Our reference: 2110490A/LT_0560:PH:bl

30 November 2009

100 Mount Street, North Sydney - Stage 1 assessment of impact of proposed commercial development on proposed CBD Rail Link

1
 A5000
 Scale: 1:100
Basement Section - East West

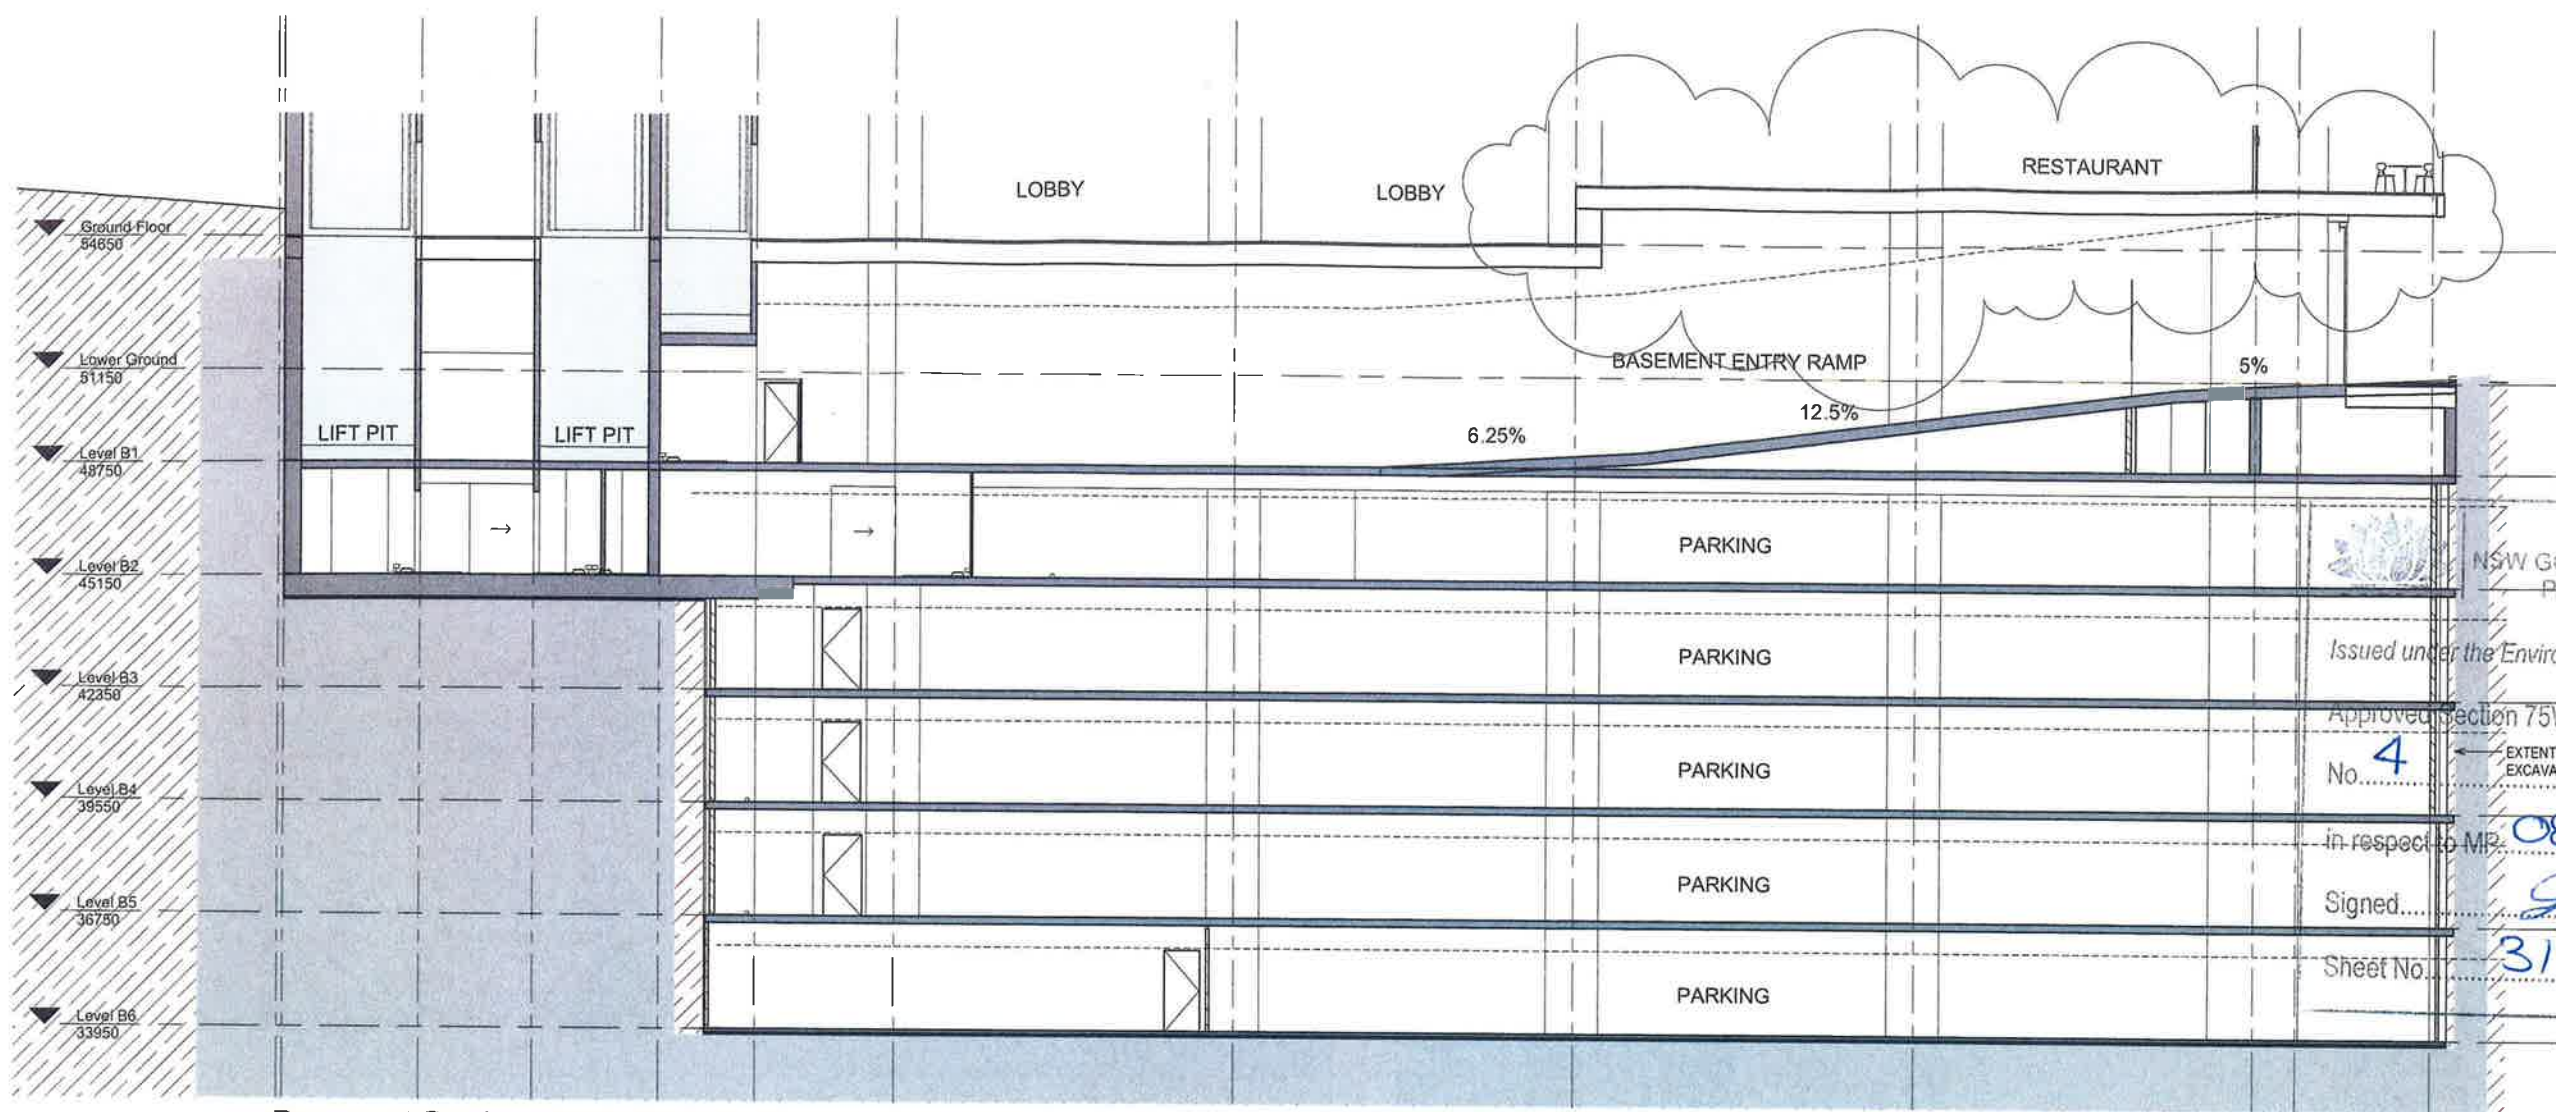
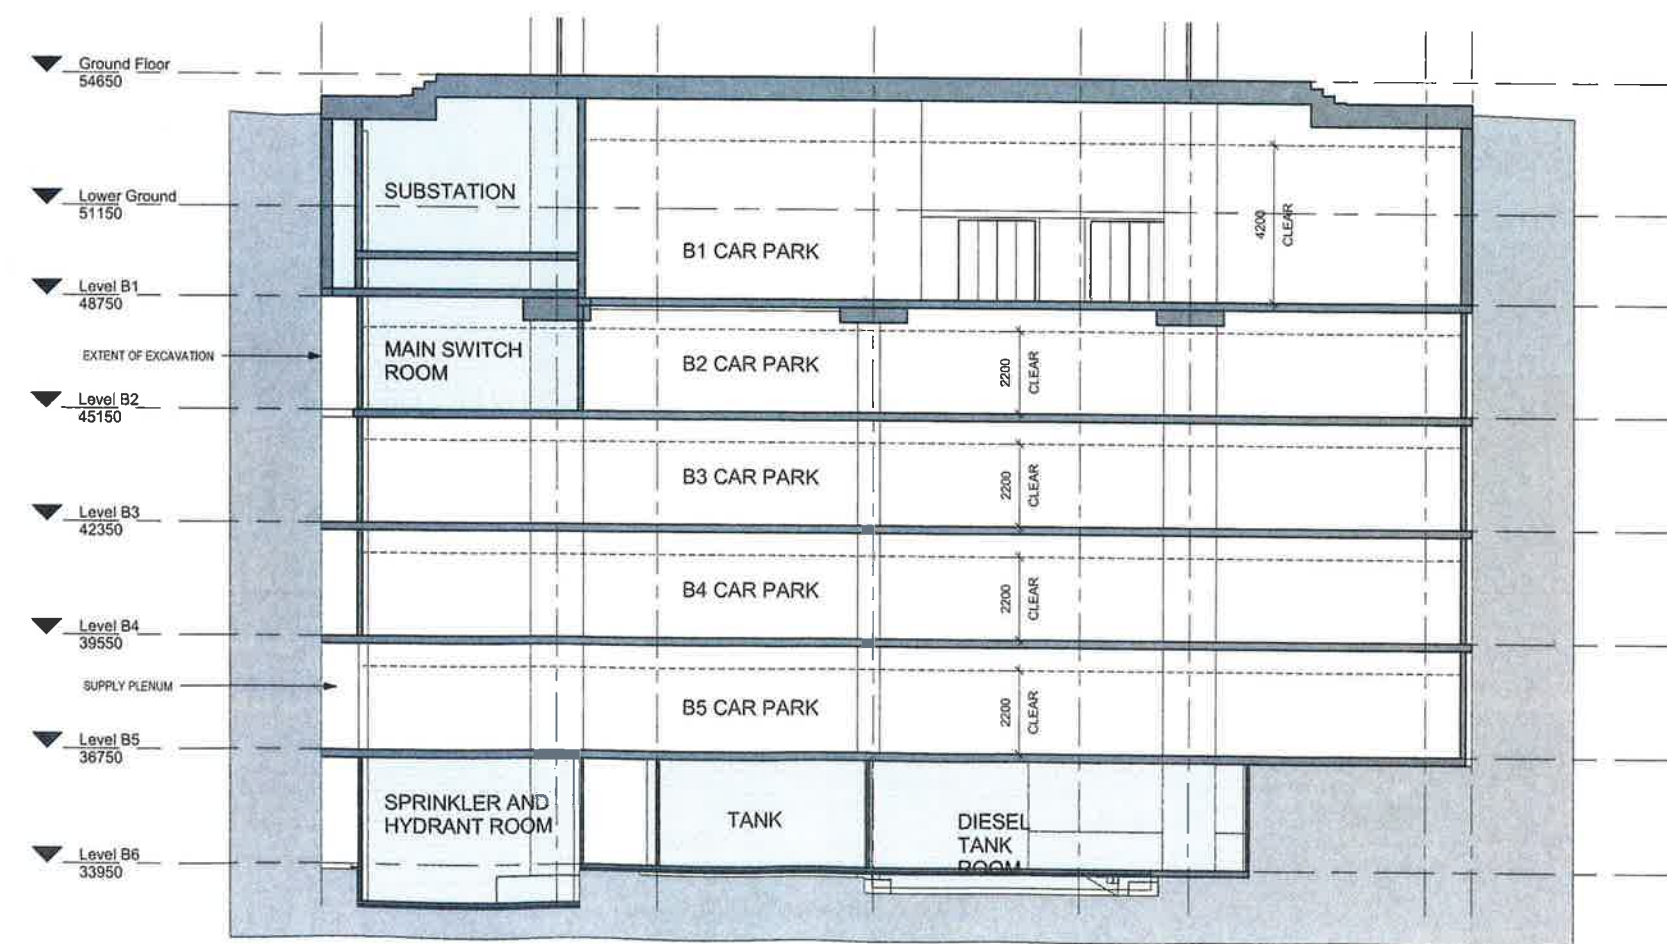
Further to our report 2110490A/ PR_6698 Rev C of 7/8/09, we now understand the expected minimum vertical clearance between the underside of basement excavation to the crown of the station cavern has been reduced by about 2 metres, such that the expected minimum vertical clearance between the underside of basement excavation and building foundation footing to the crown of the station cavern is around 6 metres.

For the reduced clearance the proposed basement excavation extends into proposed protection Zone 4 around the Paid Concourse area of CBDRL at Mount Street station, and is potentially within the more critical zones 1, 2 and 3.

For the 8 metres clearance, our previous report indicated vertical settlement at basement level can reasonably be expected to be less than about 20 mm at the southern perimeter of the development which coincides with the northern kerb of Mount Street. In the unlikely event that shale lenses and shale breccia zones are encountered these values could increase by up to 30%. Conventional ground reinforcement techniques could probably be used to provide a reasonable degree of certainty that these displacements do not cause adverse impacts on the CBDRL infrastructure. For the reduced 6 metres clearance, we expect the corresponding vertical settlement could increase to at least 30mm. Impacts on the proposed building developments would need to be accommodated in the building design.

Stability of the excavation will also depend on the thickness of the immediate beam of sandstone in the crown, and the presence of rock of lower stiffness relatively close to the crown beam. There is insufficient geotechnical data, at this time, to quantify these effects.

For the reduced clearance, it is feasible if the proposed structure is designed to accommodate the displacements that can be induced by tunnel excavation. Basement excavation at 100 Mount Street can be expected to result in minor changes to existing ground stress, groundwater regime and deformation in the ground around the proposed cavern. Provided, proposed geotechnical investigations reveal the absence of lower stiffness rock relatively close to the crown beam, we assess that these effects are not expected to adversely impact the future construction of the proposed CBDRL in 100 Mount Street.

As indicated previously, detailed analysis of expected ground movements is recommended following further ground investigations in the basement and station cavern area if these displacements are of concern.
